Recommendation Report for Prior Notification for Householder Extension

REF NO: R/107/18/PDH

LOCATION: 23 Preston Avenue
Rustington
BN16 2DF

PROPOSAL: Notification under extended permitted development rights for a single storey rear extension extending 6.5m from the rear of the original dwelling house, with a maximum height of 2.85m & an eaves height of 2.85m.

PERMITTED DEVELOPMENT, NOTES ON HEIGHTS & DEPTH:

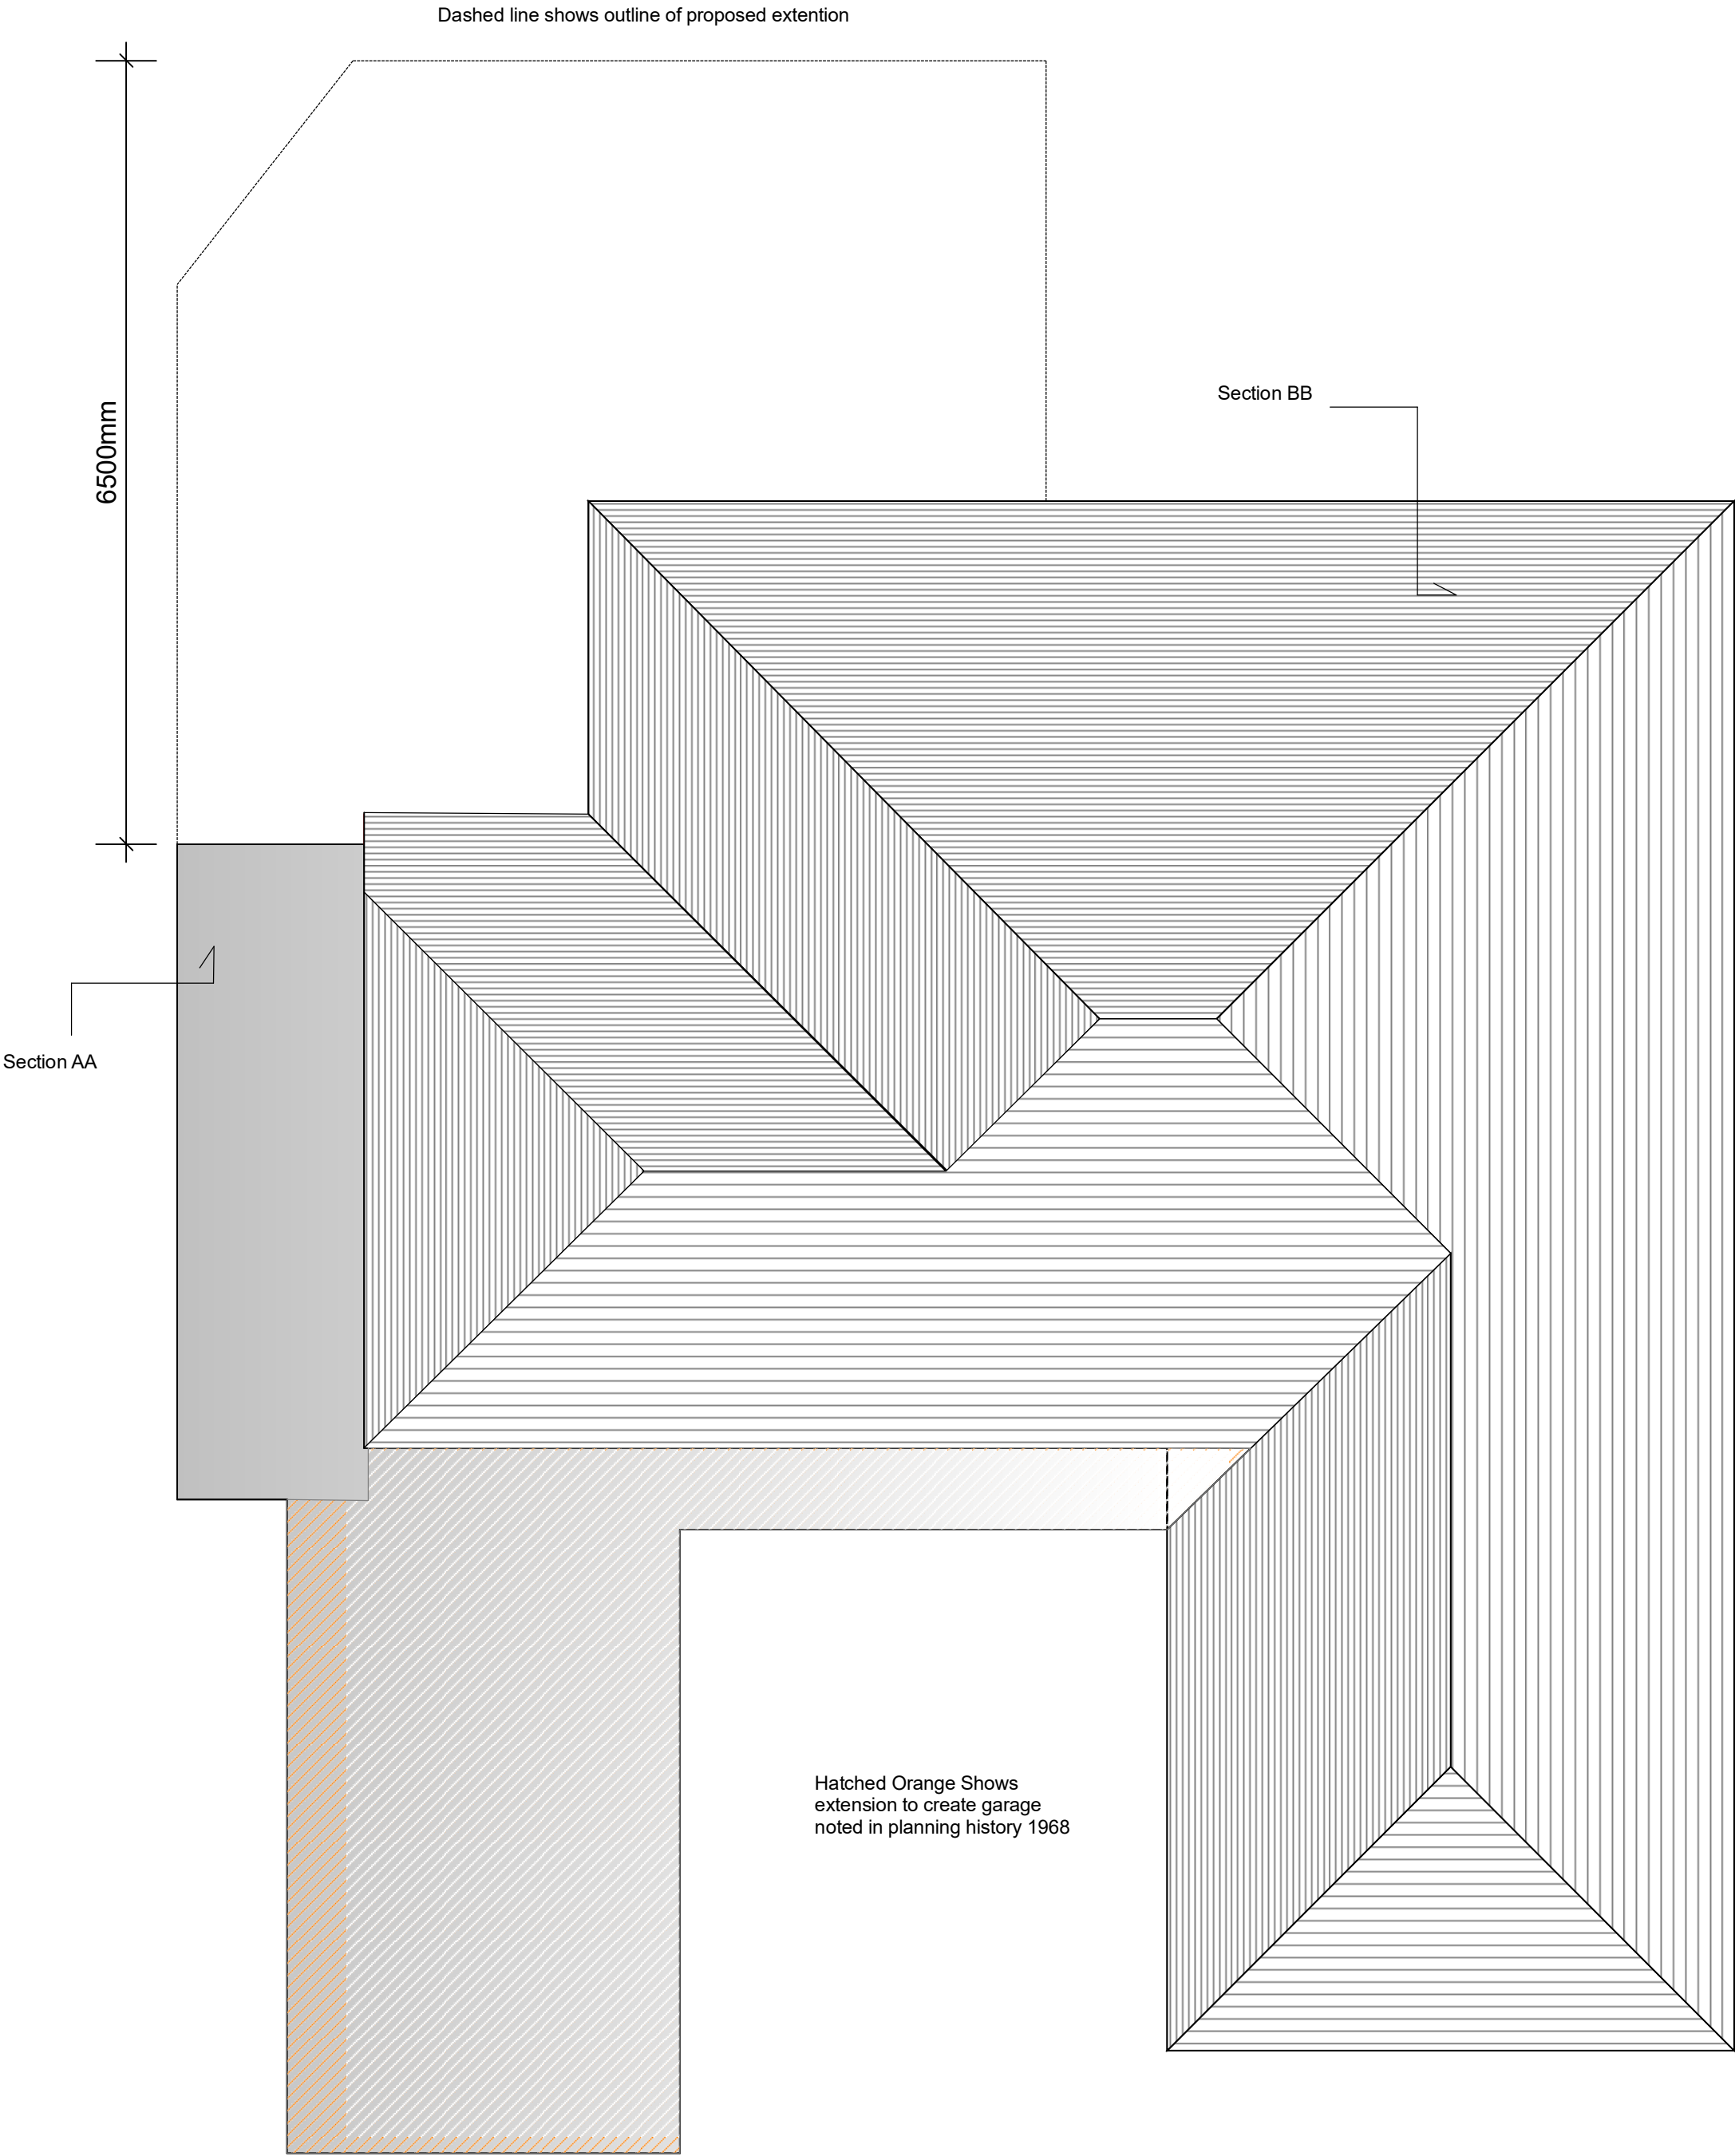
- Extension is too high and too close to the boundary
- Doesn't comply with legislation in that the height is higher than the eaves height.
- Doesn't comply with legislation in that the roof height would mean alterations to link to the existing roof
- Roof lanterns would increase adverse visual impacts
- Out of character with other properties
- Block plan is misleading
- Room should be allowed for maintenance to boundaries walls.
- Depth of the property will increase by 50%
- Lack of natural ventilation means vapours/ odours from the kitchen will vent to neighbouring properties
- Re-configuration of the internal dwelling will be different to neighbouring properties

Confirmation of eaves height and total height of the proposed development were requested and additional plans were submitted. For clarification the eaves height is measured from the base of the external wall of the extension to the point where the external wall would meet the upper surface of roof slope.

The proposed extension will measure a maximum of 6.5 m depth. The proposed eaves height and total height will be 2.85m to match that of the existing dwelling.

The proposed extension will be constructed to a height of 2.85m and will match that of the existing dwelling as shown in the approved plan and will be constructed with a flat roof. It should be noted that a structure can be constructed under Permitted Development to a height of 4m without the need for a formal planning application. In addition the presence of hedging of sufficient height will mean that there will not be an unacceptably adverse overbearing impacts upon the neighbouring property at No.7 or other adjoining neighbours. The proposal is also for this reason not considered to give rise to any loss of privacy due to outlook or any loss of light.
